Recommendation Report for Planning Permission for Works or Extension to a Dwelling

REF NO: FG/68/19/HH

LOCATION: 4 Elverlands Close
Ferring
BN12 5PL

PROPOSAL: Single storey rear extension to replace existing conservatory and a new dormer window to rear roof slope

PROPOSED ELEVATIONS 1:100@ A2

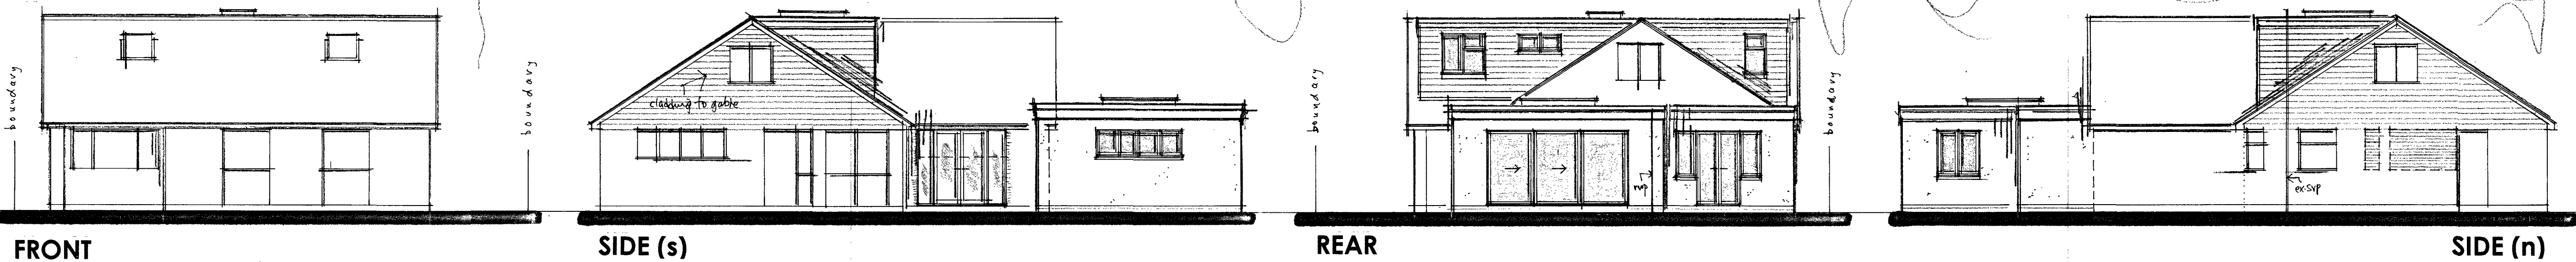
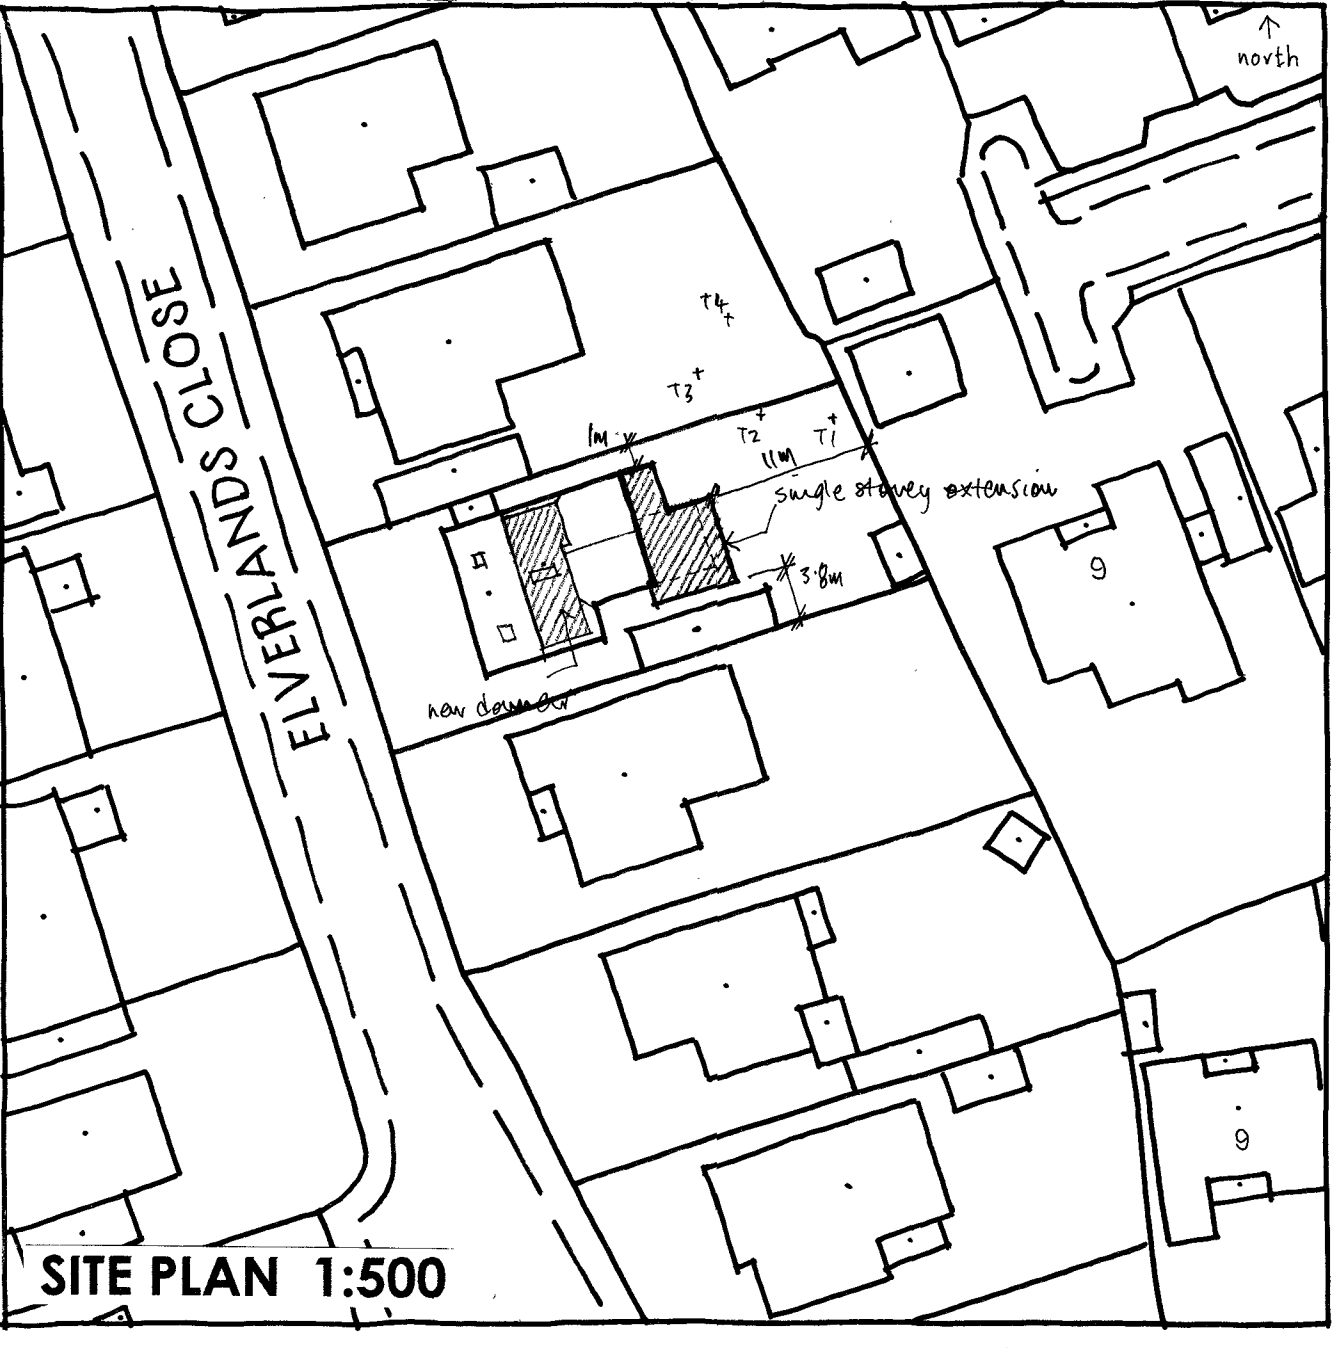
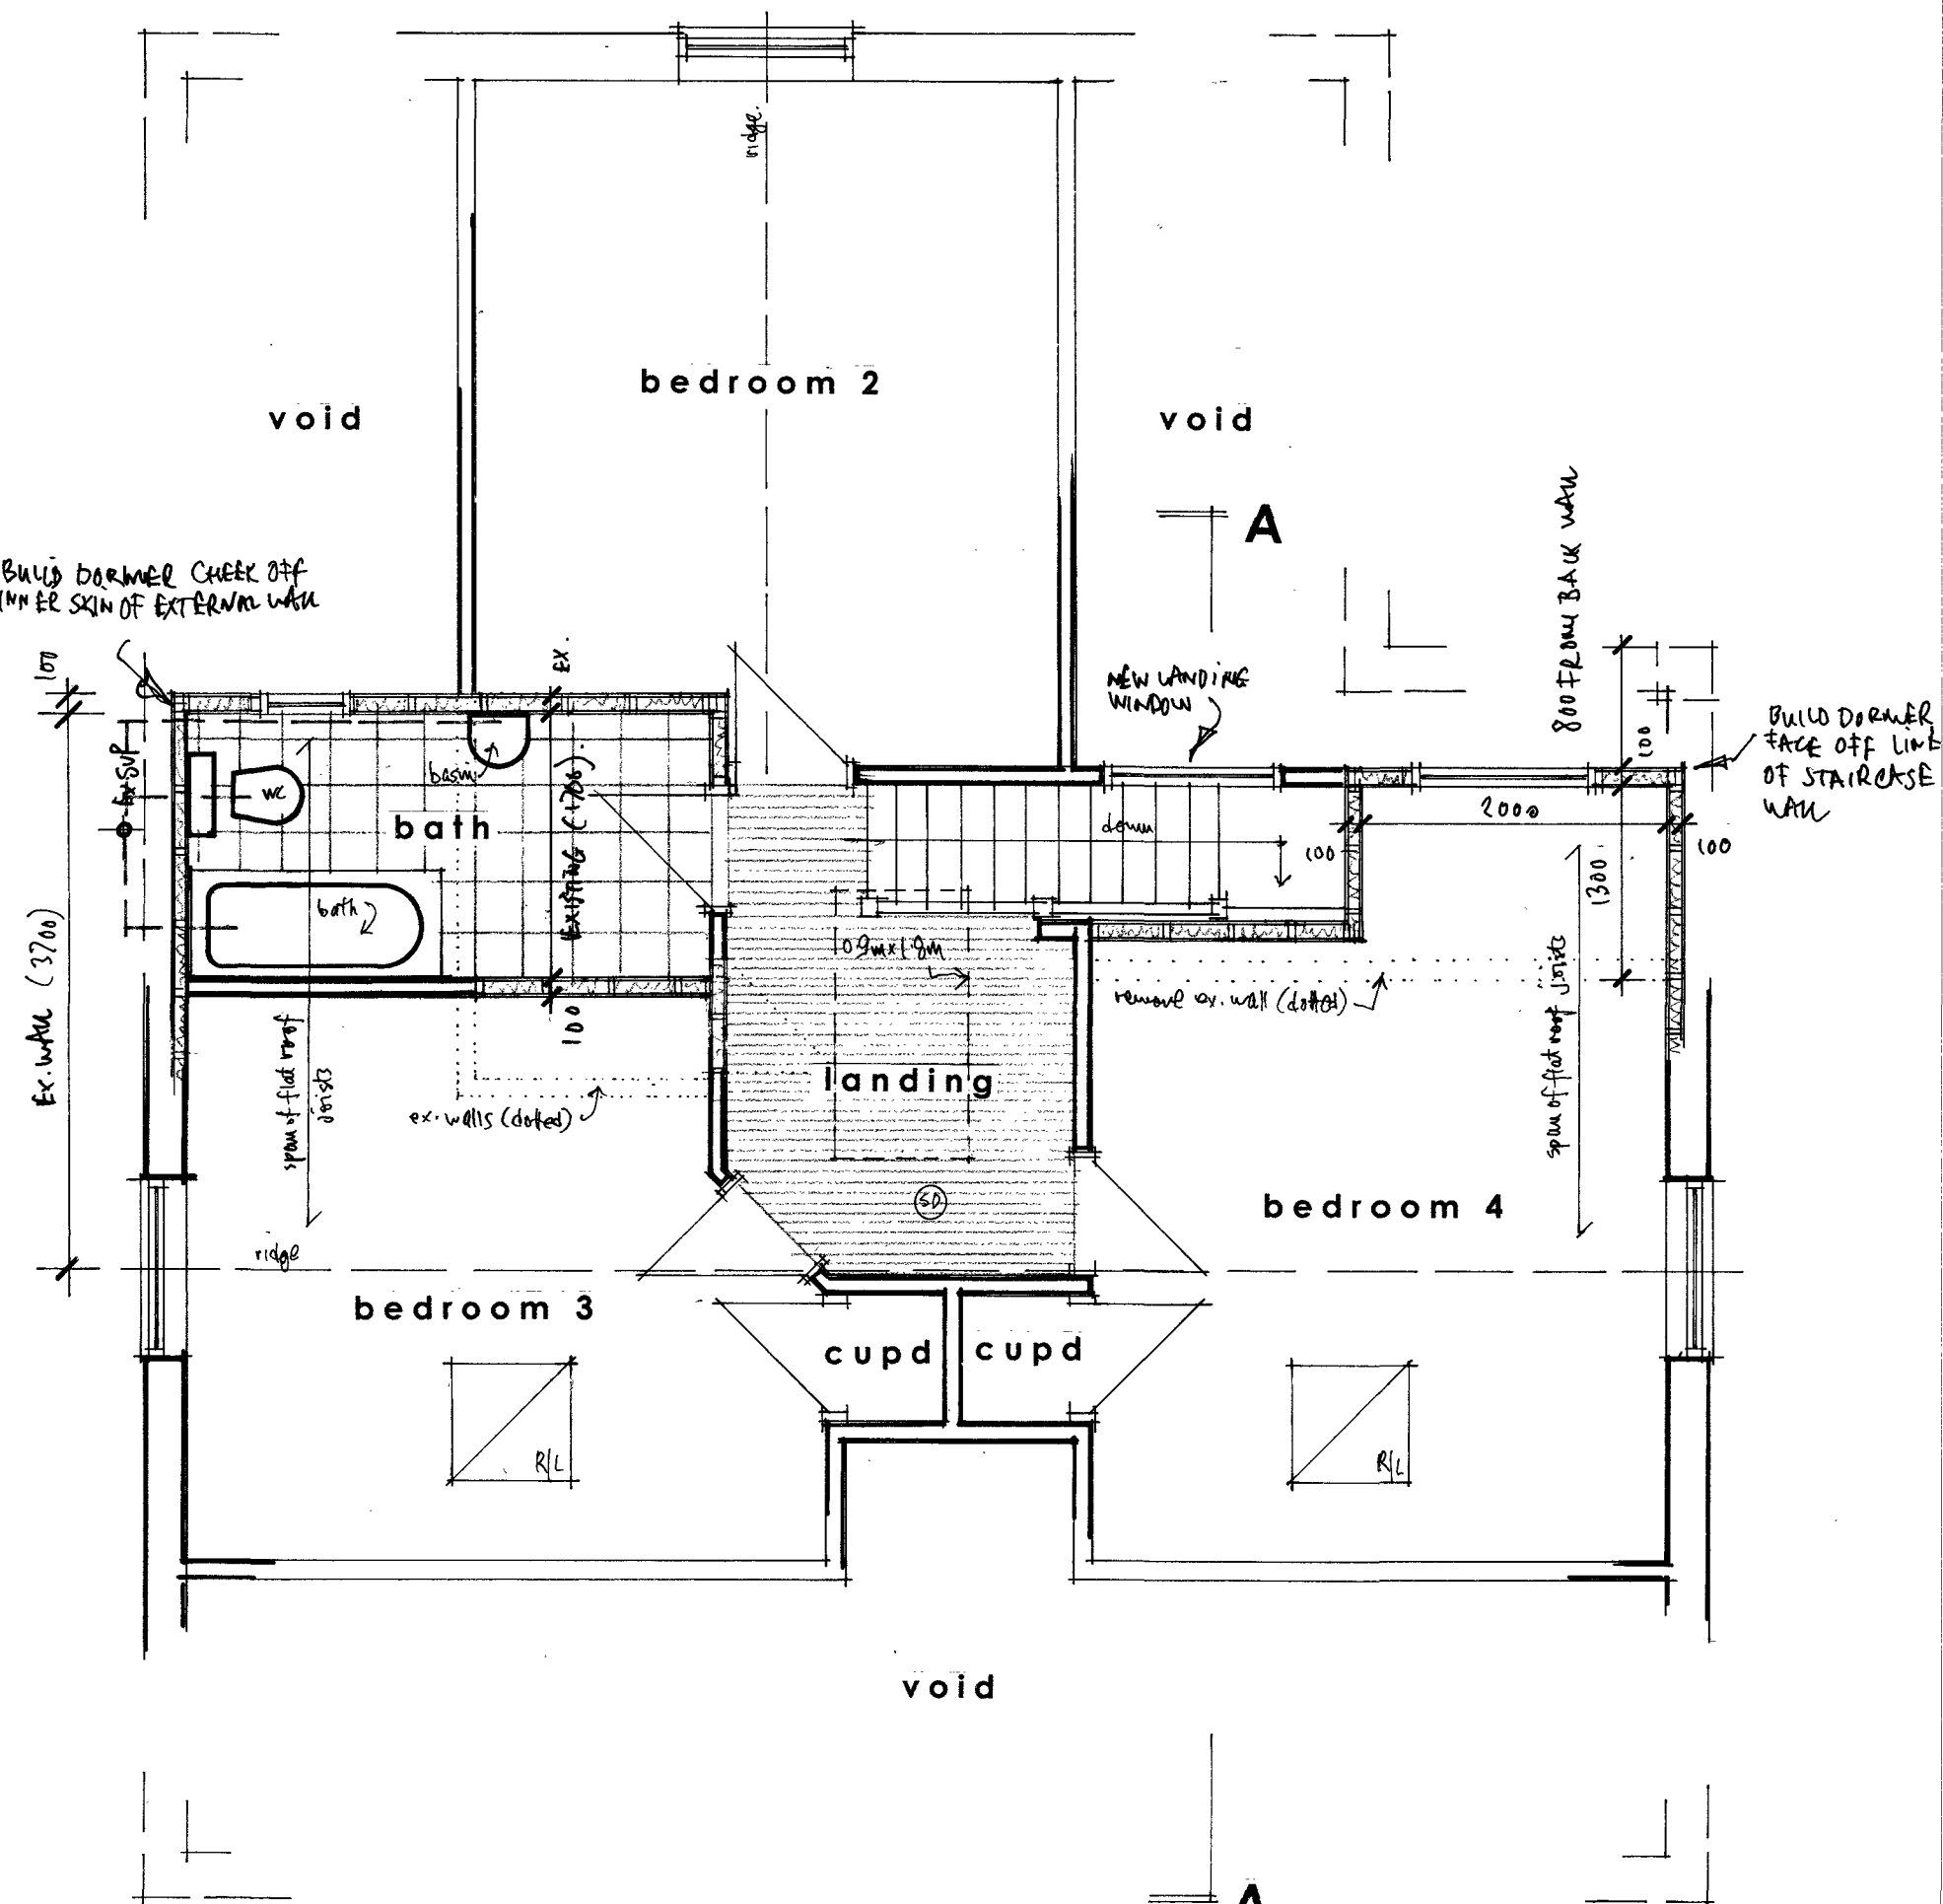
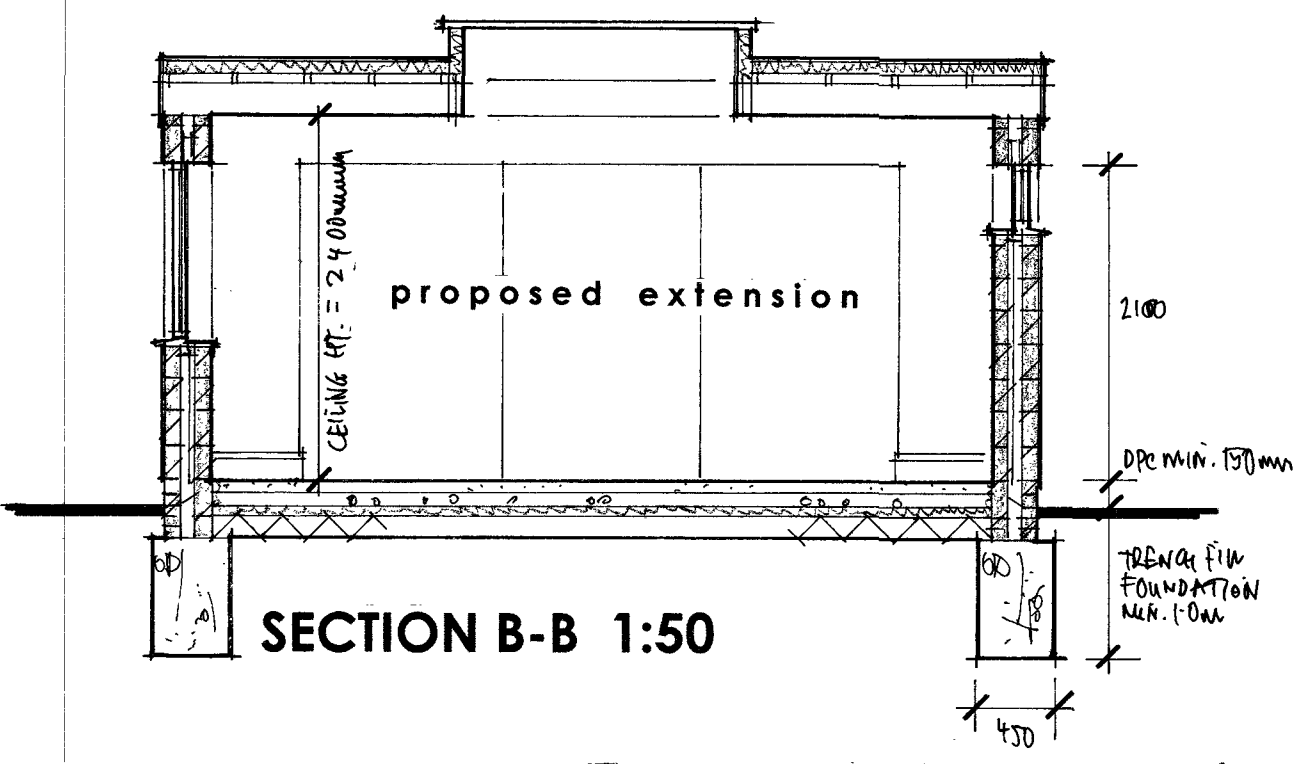
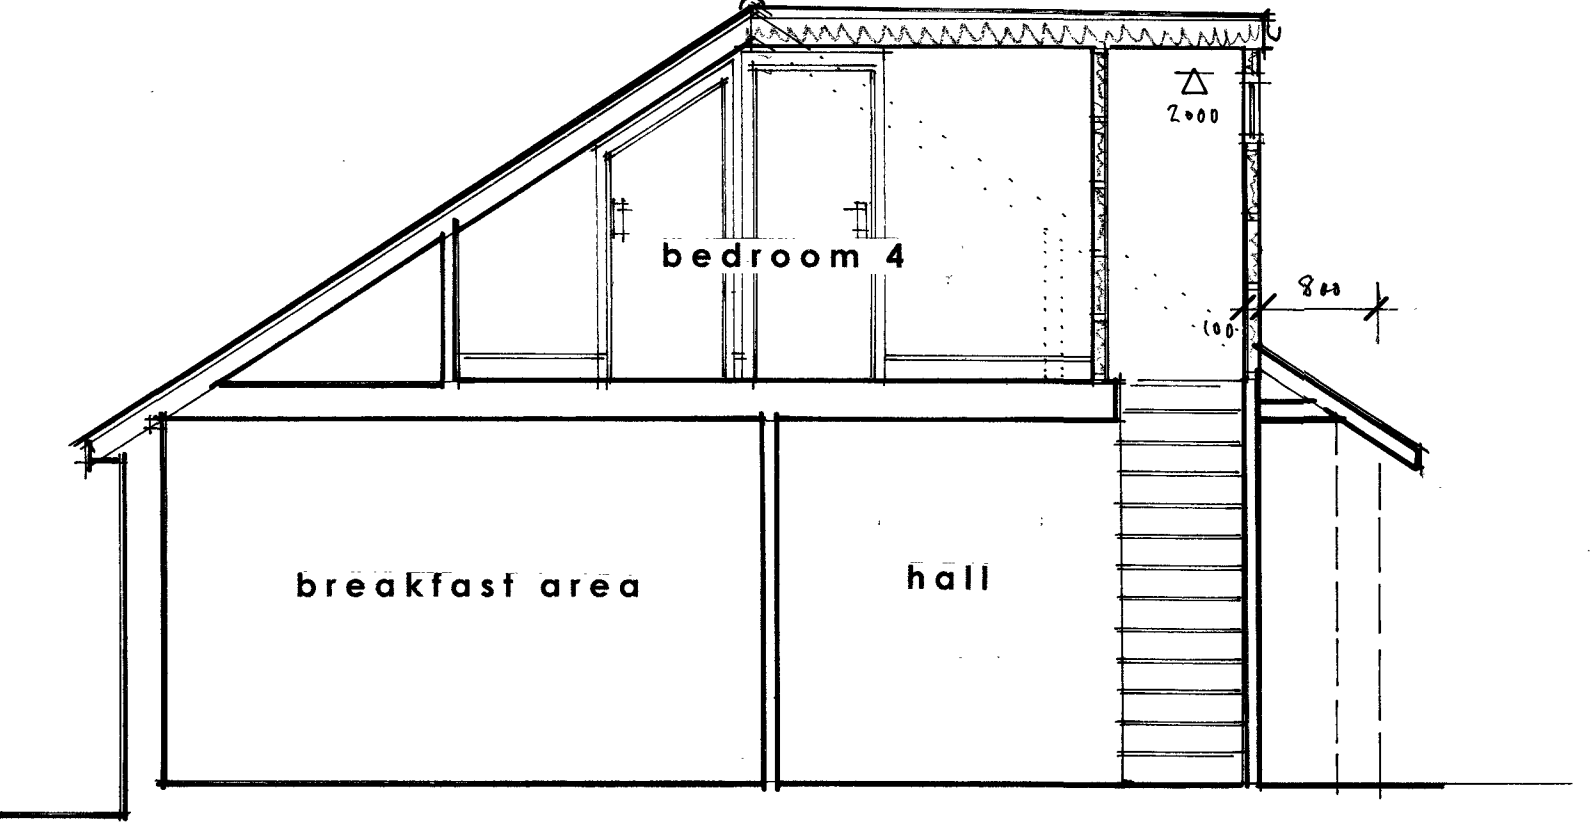
Resultant of its location, the proposed single storey rear extension is not visible from the street scene. It has a maximum roof height of approximately 3m, which is approximately 2.4m lower than the ridge height of the proposed host dwelling (if the development were to be completed). The proposed rear extension is not considered to have any significantly harmful impact upon the character of the host dwelling or its locality. Therefore, the proposed rear and side extensions are considered to be in accordance with D DM1, D DM4(a) and (b) of the Arun Local Plan.

The proposed roof alterations are not considered to have a significantly detrimental impact upon the character of the host dwelling, or the wider locality. It is noted that the proposed development constructs a dormer window that spans the whole width of the roof, and therefore, the roof alterations are not considered to be subservient to the host dwelling. However, due to its design (set in from the sides, below ridge height and sloping side roof), it is sufficiently well integrated with the appearance of the host dwelling. Additionally, there are examples of similar development within the locality, which is considered to allow the proposal to have no significantly harmful impact upon the character of the locality.

Whilst it is considered that the proposed development is in conflict with D DM4(b) of the Arun Local Plan, it is considered that the proposed development is in accordance with D DM1 and D DM4(a) of the Arun Local Plan.

The proposed development is not considered to have any significantly harmful impact on the residential amenities of neighbouring occupiers. This is as a result of its siting and scale allowing no significantly harmful overshadowing of the occupiers of #5 and #3 Elverlands Close. The proposed rear dormer windows provide views into the rear and gardens of neighbouring dwelling. However, the impact on residential amenity is considered acceptable. The bathroom window to the rear needs to be obscure glazed to ensure that the proposal is considered to be acceptable with regards to neighbouring

Reason: For the avoidance of doubt and in the interests of amenity and the environment in accordance with policy D DM1 of the Arun Local Plan.
- 3 The window at first floor level in the on the rear elevation of the building shall at all times be and remain glazed entirely with obscure glass.

- 4 No cladding shall be erected until details of the cladding have been submitted to and approved by the Local Planning Authority.
